The Planning
Inspectorate

A14 Cambridge to Huntingdon Improvement – Draft Documents Meeting

File reference: TR010018

Date: Tuesday 7 October 2014

Drawing title: **LAND PLANS REGULATION 5(2)(i) SHEET 1 OF 40**

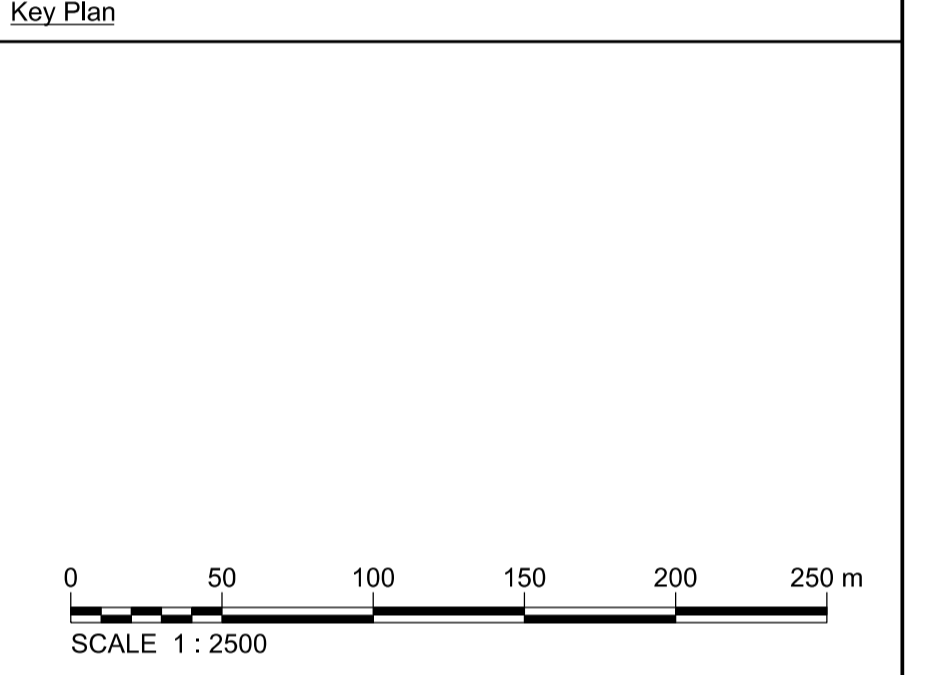
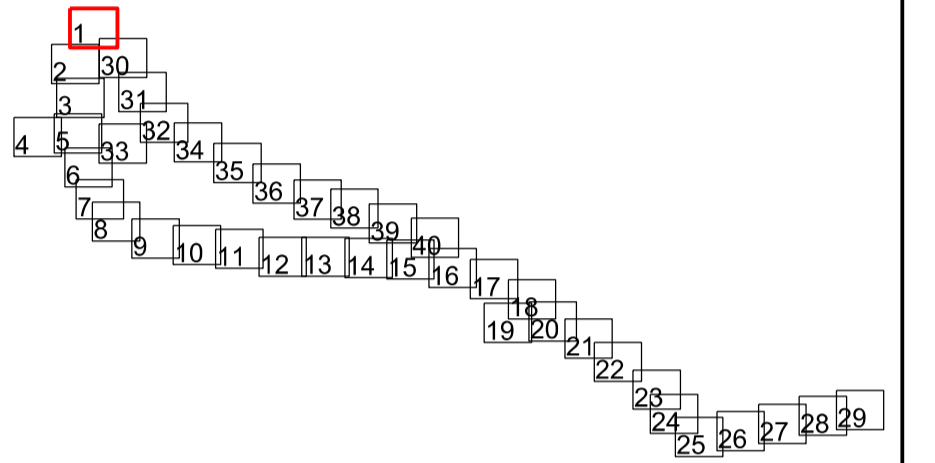
The works plans were all in order. The Inspectorate noted that it was not clear on all plans where land fell within the order limits, and suggested that the HA consider shading the land within the order limits to make this more clear.

The Inspectorate stated that there were a number of inconsistencies between the Book of Reference (BoR) and the land plans. These included plots identified within the BoR but not clearly shown on the plans, and it was proposed that insets could be used to more clearly identify small plots of land (Please see Annex A for a summary of inconsistencies between plans and Part 1 of BoR). The HA stated that the BoR is currently being rewritten and plans revised to address these points.
